Ref: 6/2020/3306/FULL
Date: 07/01/2021

HISTORIC BUILDINGS AND CONSERVATION ADVICE

RE: 52 & 54 Bridge Road, Welwyn Garden City, AL8 6UR

The application is for the construction of two, two-storey detached houses with accommodation in the roof space and associated parking and access on the land to the rear of 52 & 54 Bridge Road.

Drawing No: 1644.P.02

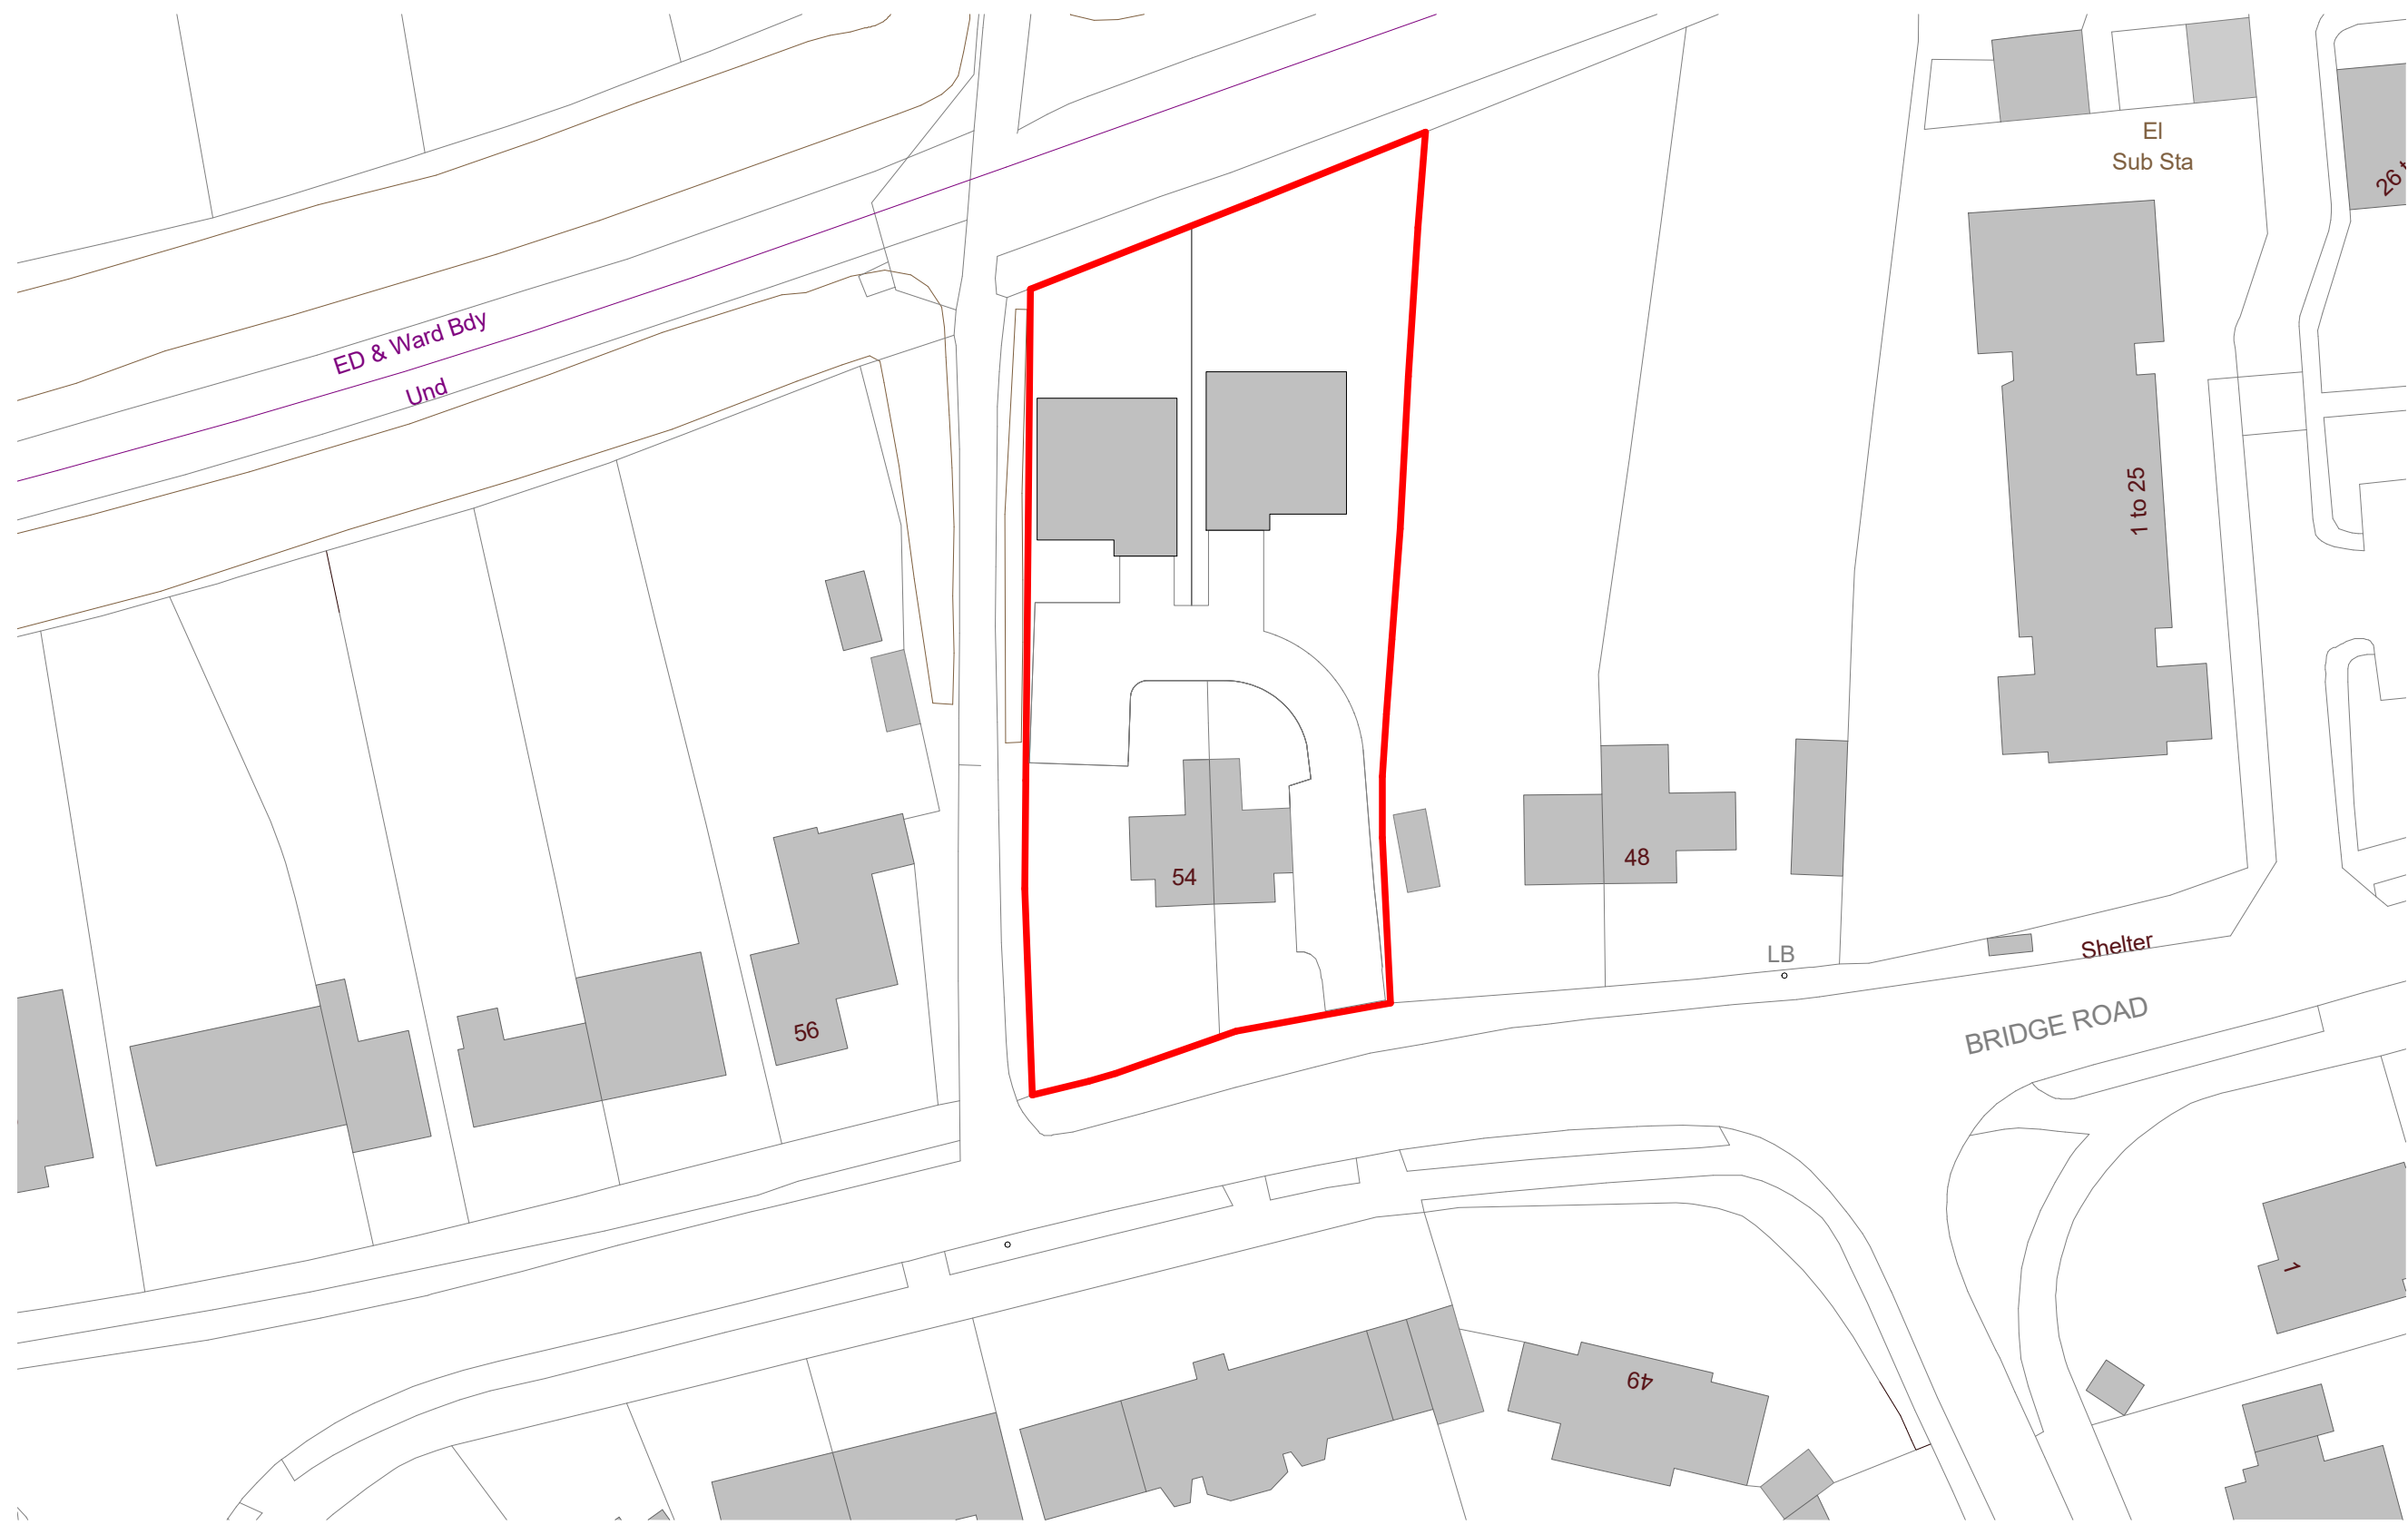
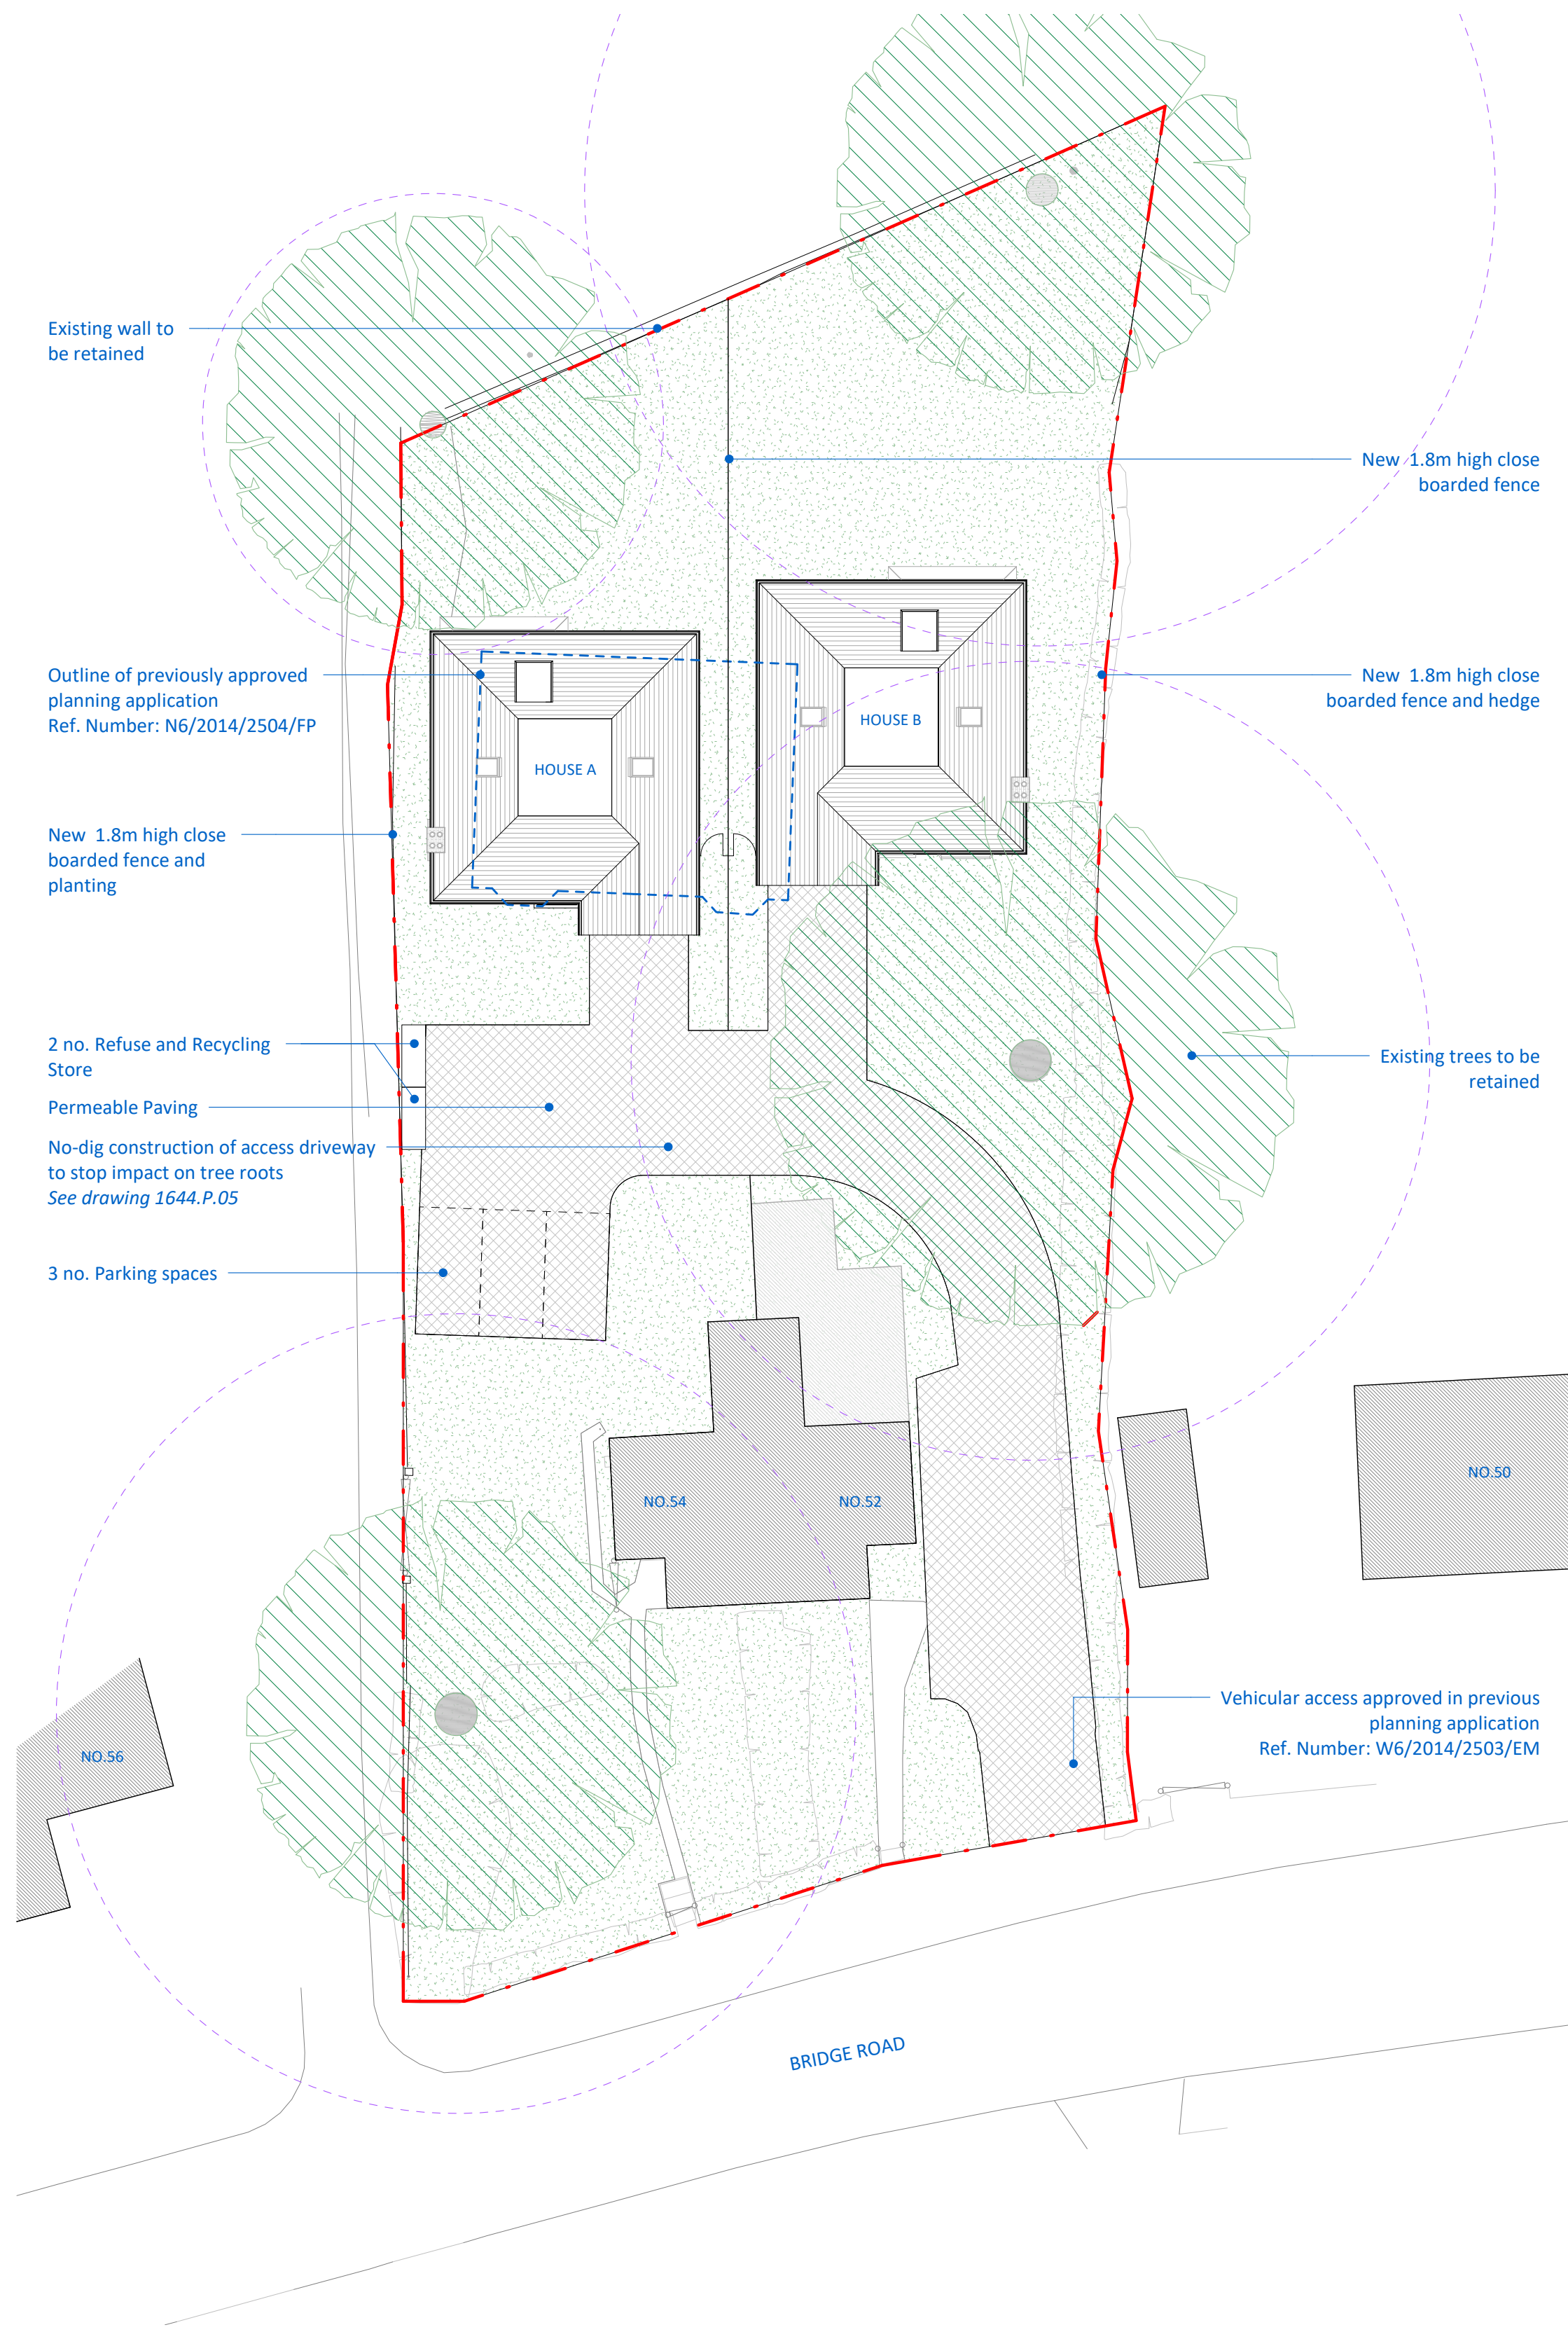
Historically, the land to the rear of nos. 52 & 54 was undeveloped and the houses of the Garden City were laid out in a linear pattern along the northern side of Bridge Road. The proposed dwellings are at odds with the prevailing linear development and impact on the setting of nos. 52 & 54 by infilling the undeveloped land between them and the pre-Garden City features of the former railway line and Sherrardspark Wood. The proposed houses are also larger than nos. 52 & 54 and have an unsympathetic crown roof form, further detracting from the quality of the traditional building stock within the Conservation Area.

The proposed dwellings would also undermine the verdant appearance of this part of the Conservation Area by obscuring views of the trees at the rear of the site along the footpath in views from Bridge Road down the proposed driveway.
